Application for a non-material amendment following a grant of planning permission.

Number	<input type="text" value="5"/>
Suffix	<input type="text"/>
Property name	<input type="text"/>
Address line 1	<input type="text" value="Post Office Lane"/>
Address line 2	<input type="text" value="Hanwood"/>
Address line 3	<input type="text"/>
Town/city	<input type="text" value="Shrewsbury"/>
Postcode	<input type="text" value="SY5 8LR"/>
Description of site location must be completed if postcode is not known:	
Easting (x)	<input type="text" value="344631"/>
Northing (y)	<input type="text" value="309836"/>
Description	<input type="text"/>

<input type="text" value="Erection of extensions and alterations"/>	
Reference number:	<input type="text" value="18/03257/FUL"/>
Date of decision	<input type="text" value="02/01/2019"/>

Client no longer wishes to construct the first floor extension over what will be the family room and instead wish to remove the low single pitched roof over what is currently a storage room (conversion works for this part of the dwelling have not yet taken place) and erect a new 40 degree pitched roof (to match existing) over, omit the window to the north east elevation and i

Drawing Name
Proposed Floor Plans

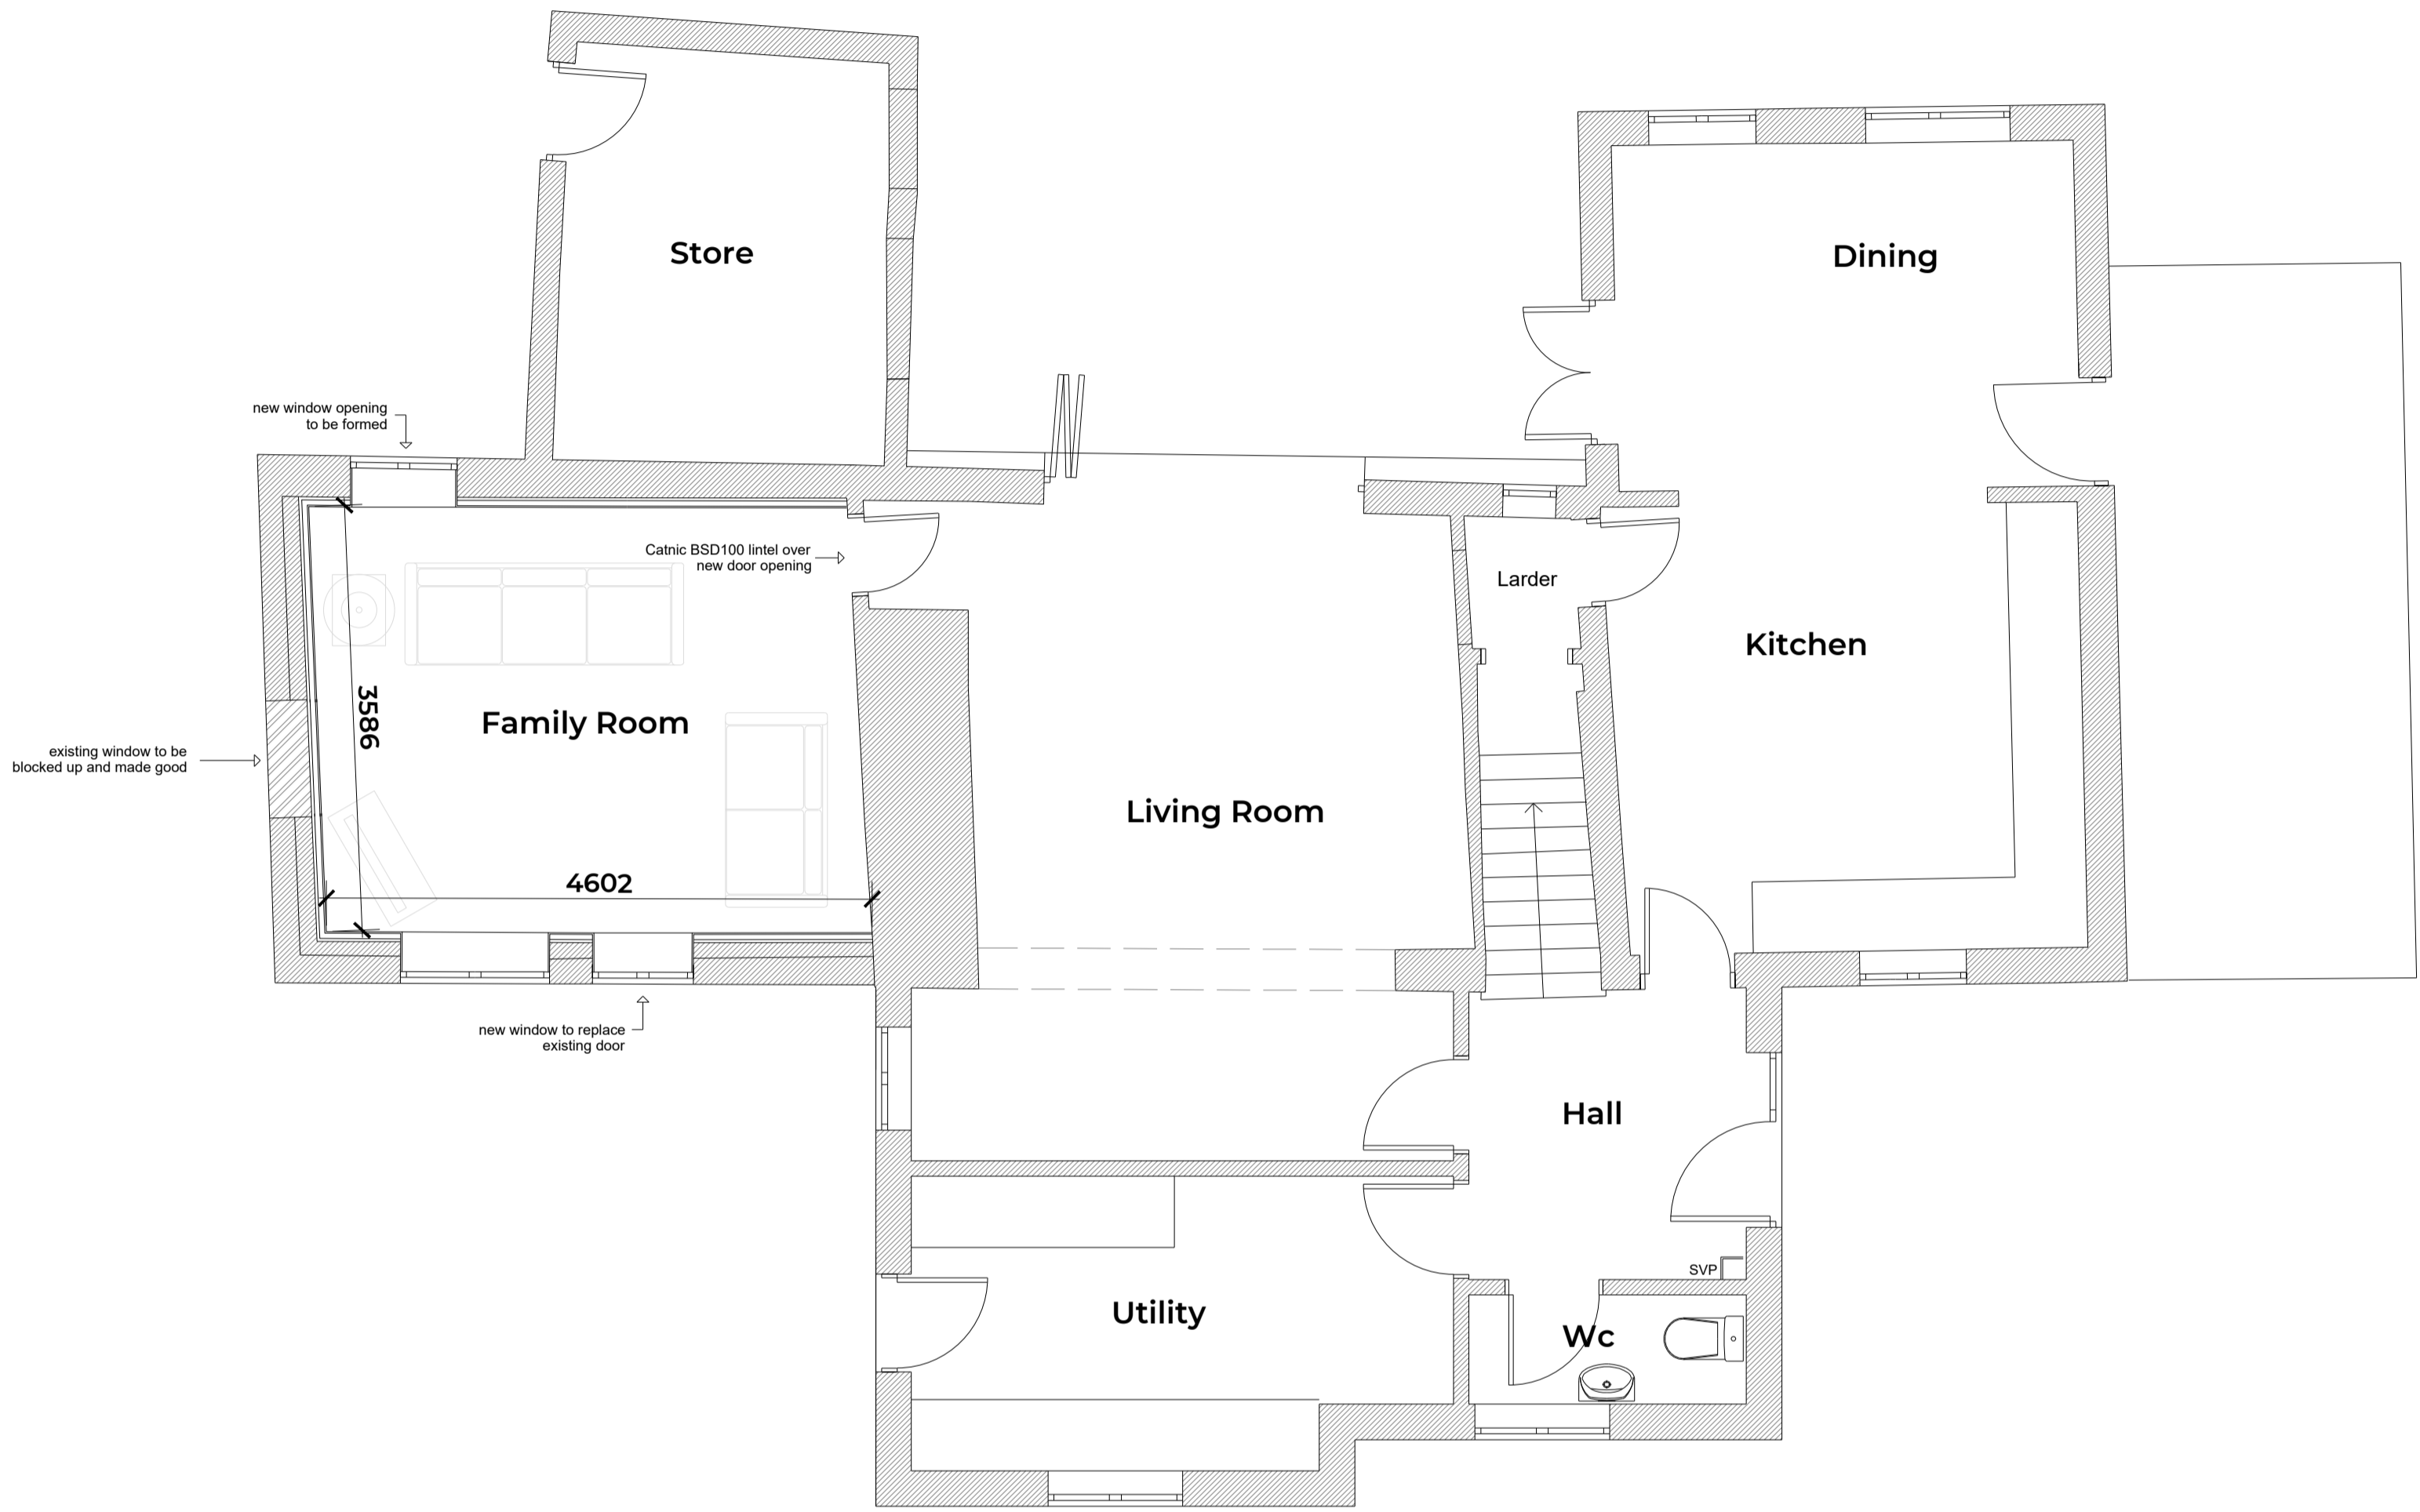
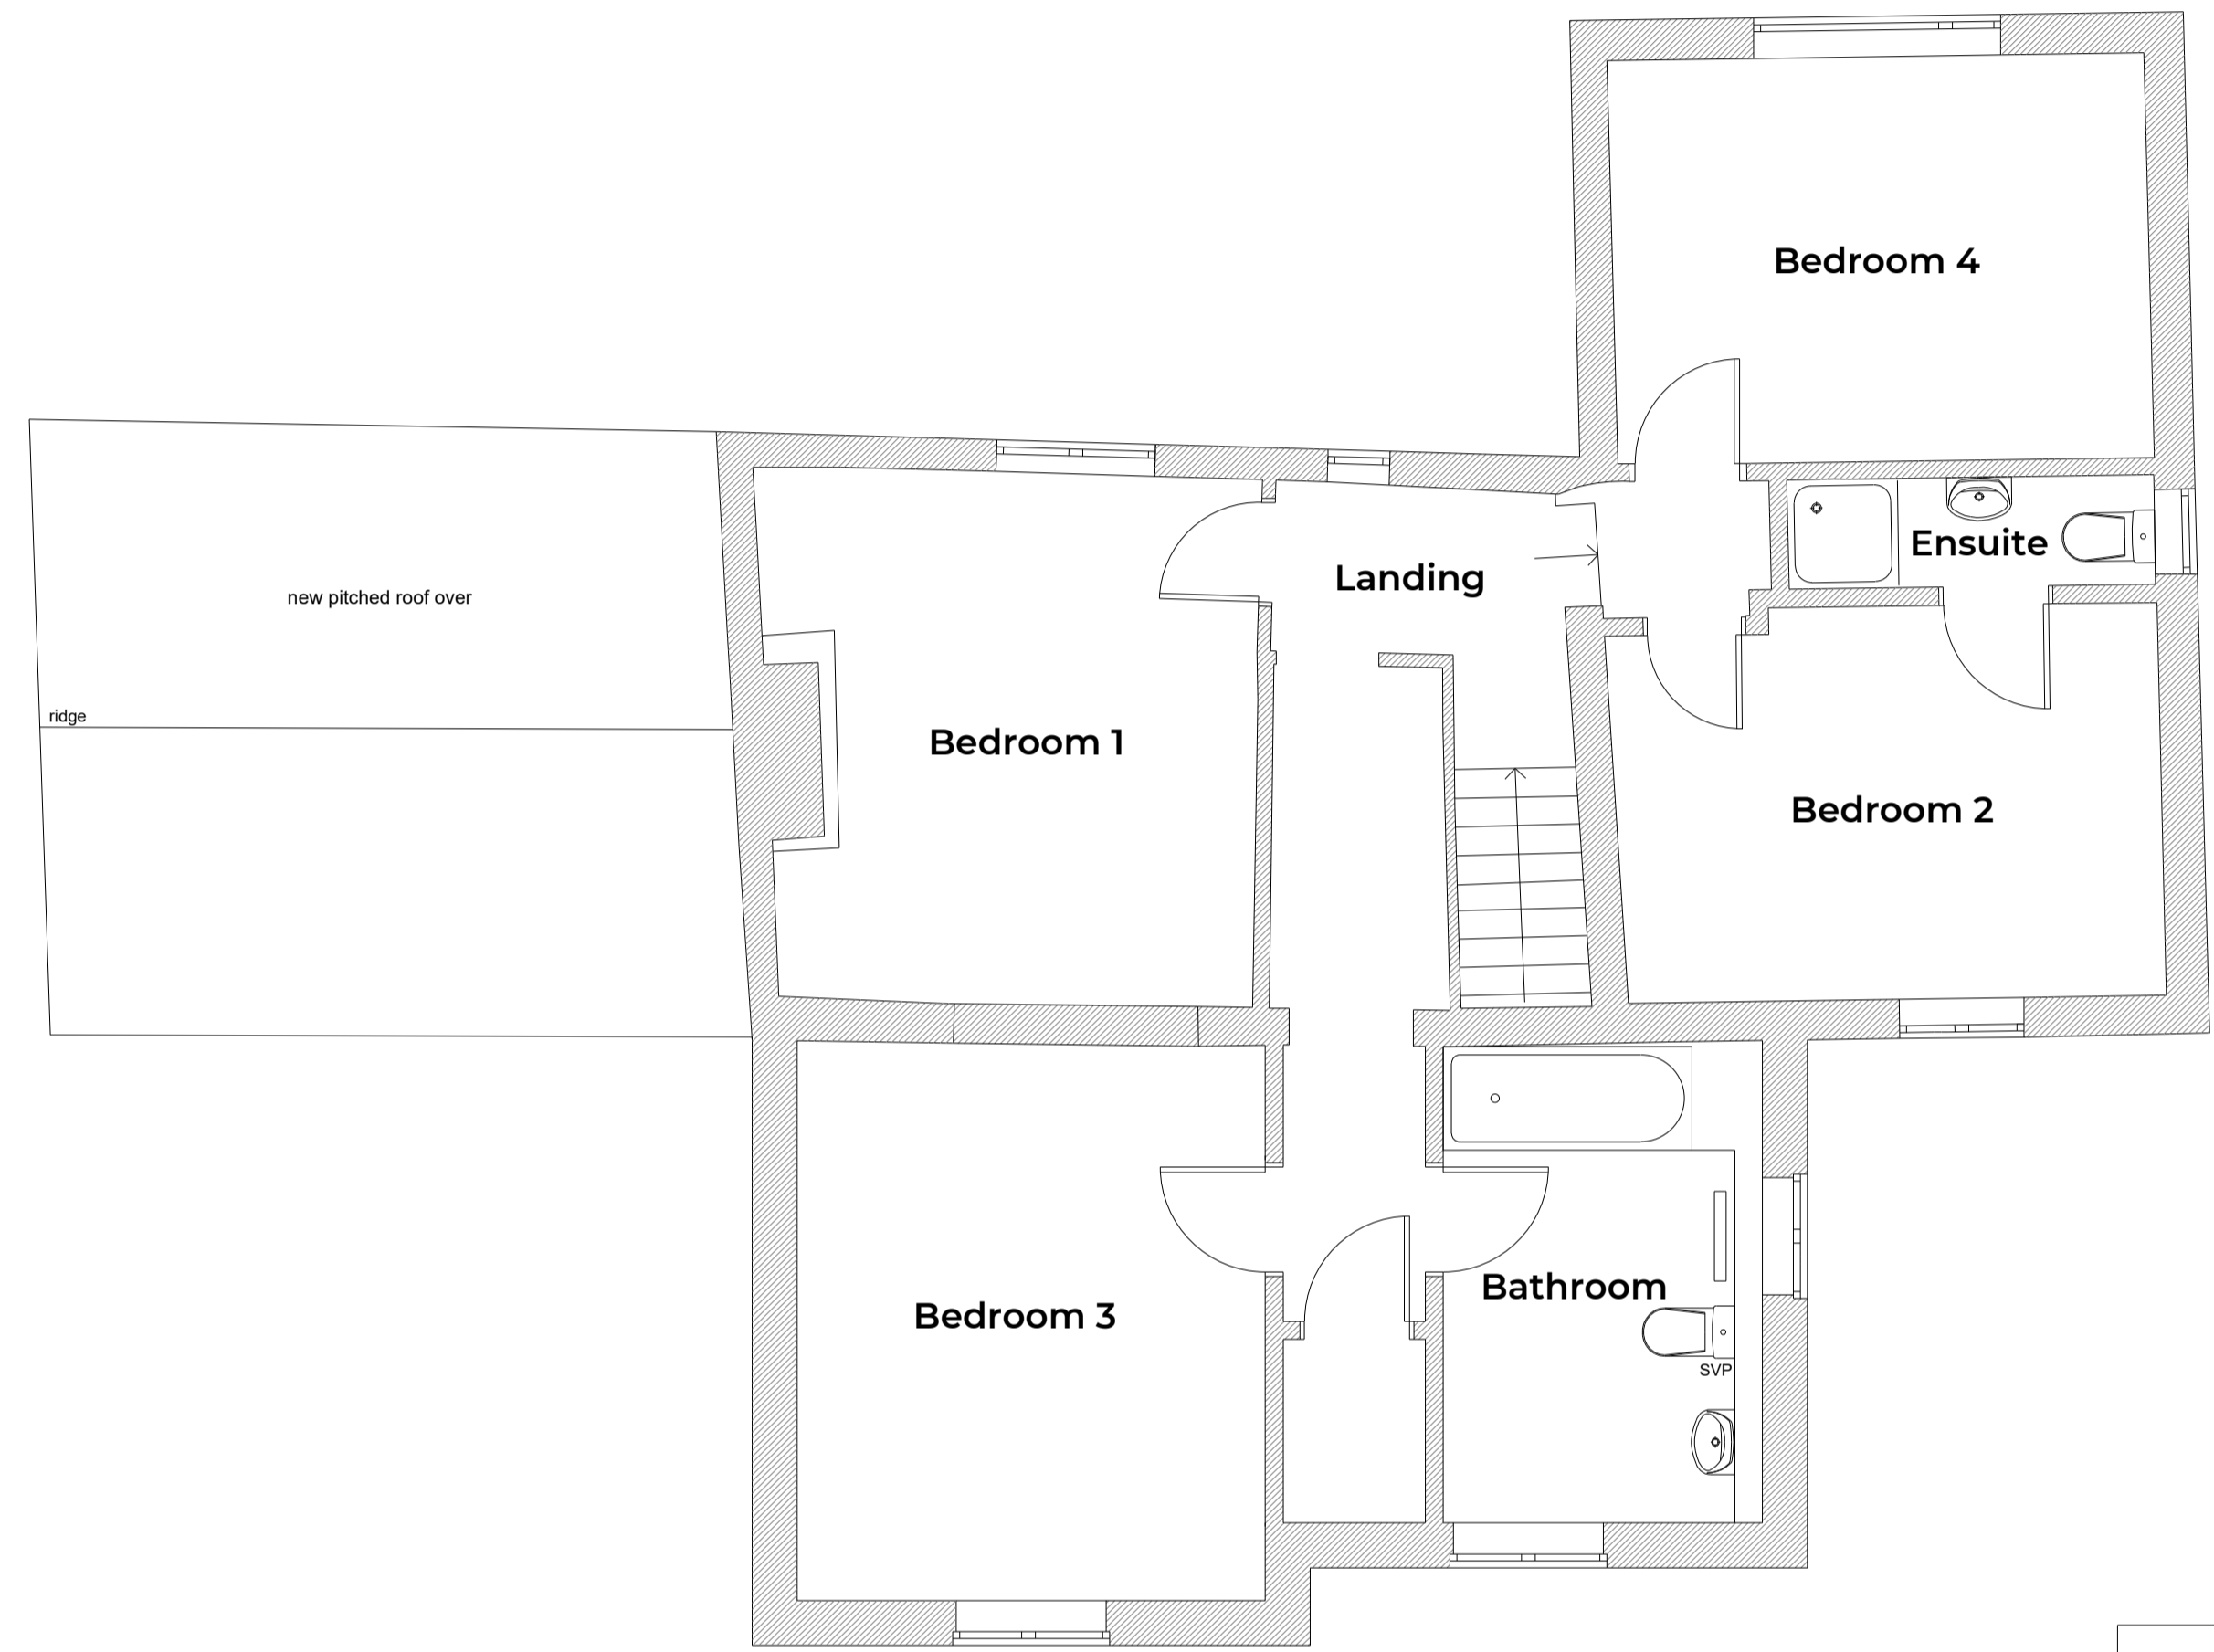
Client no longer requires ensuite and dressing room to bedroom 1 (as shown on drawing no. LGA 003 D02 REV A)
